**BARANGAROO HEADLAND PARK AND NORTHERN COVE MAIN WORKS  
PROPOSED MODIFICATION TO APPROVAL MP10\_0048  
RESPONSE TO PROFESSOR JAMES WEIRICK SUBMISSION**

Encl: Response to submission by James Weirick on MOD3 application

1 SECTION B-B
1:250

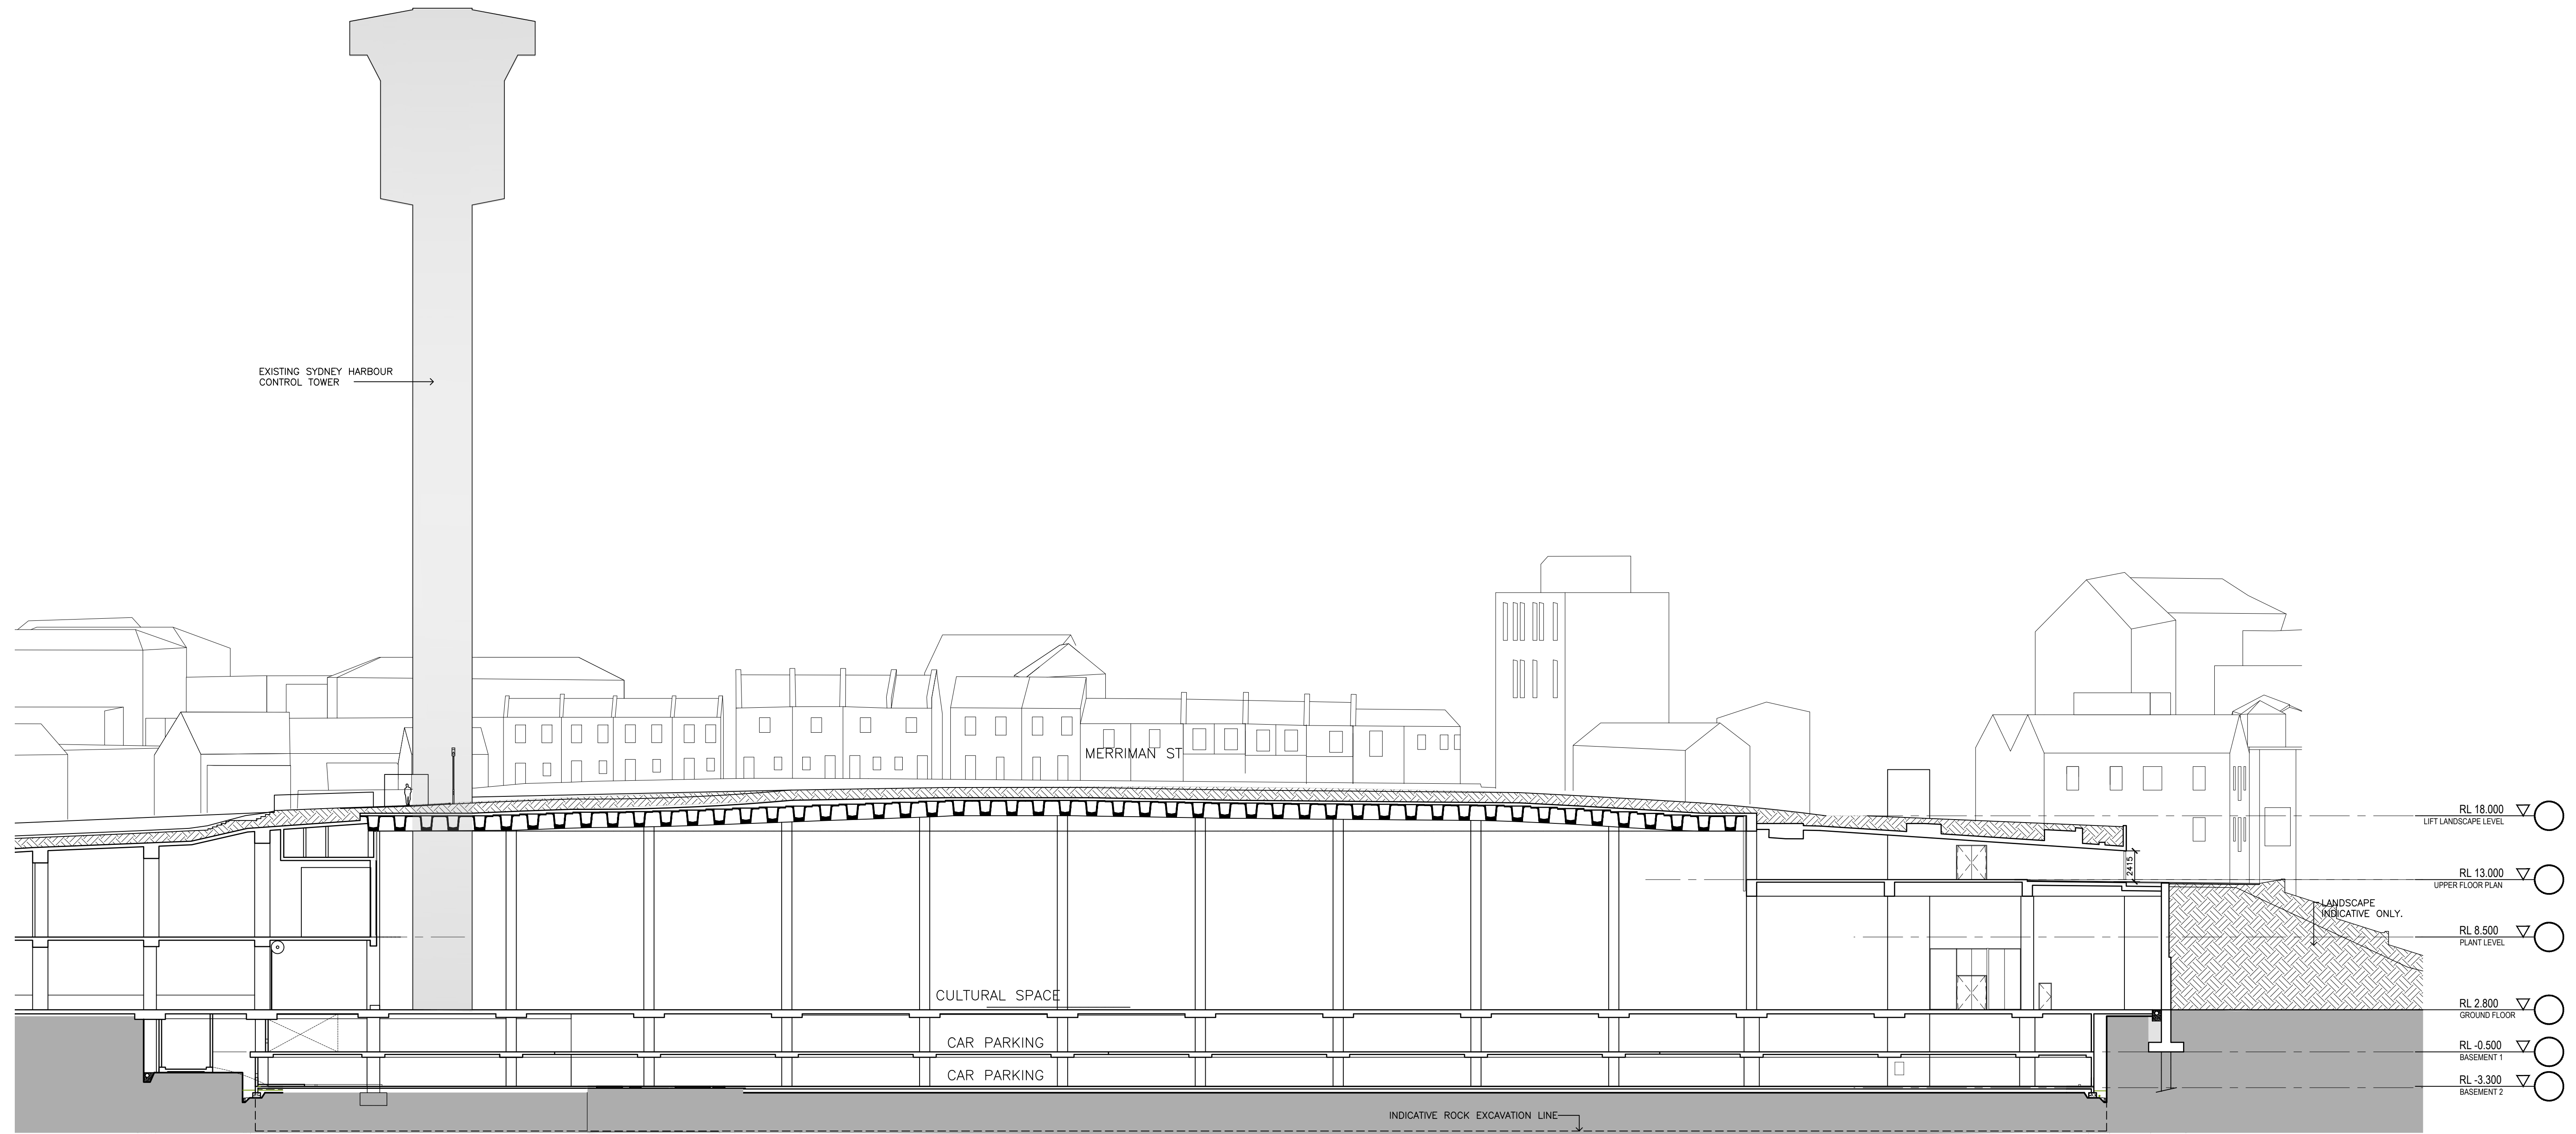
**Recommendation 2:** The 'Super T' post-and-beam roof structure to the underground Cultural Facility proposed in MP 10\_0048 MOD 3 must not proceed. To ensure success of the 'Roof Garden' conditions of landscape on structure, involving a spatial sequence of approximately thirty (30) canopy trees and associated plantings, the original profile of the Cultural Facility roof slab approved as part of the Headland Park Main Works Project Application in 2011, stepped north-south and east-west with integral tree pits to support major trees and drained accordingly, must be retained.

**Response 2:** The design allows for significant trees on the roof. The girders will be topped with an in-situ roof slab, overlaid by waterproofing membrane, drainage layer, thermal insulation layer. Planting soil depths suitable for the specified species at maturity remain part of the design as per the recommendations of the soil scientist Simon Leake and horticulturist Stuart Pittendrigh.

The use of 'Super T' beams are a function of 30m structural spans which in turn provide a future design flexibility for the Cultural Space. The structure gently follows the contours of the Park landscape above.

The detail design process has provided significant improvement, as it not only retains the ability for tree planting over the structure, but also:

- ☐ Eliminates sunken tree pits and the need to drain and waterproof. Avoiding risk associated with the creation of water-retaining vessels;
  - ☐ Facilitates subsoil drainage by the gently convex shape of the structure, eliminating the creation of vessel shapes in the roof;
  - ☐ Includes east-west cross falls to facilitate drainage and plant / lawn / tree health;
-
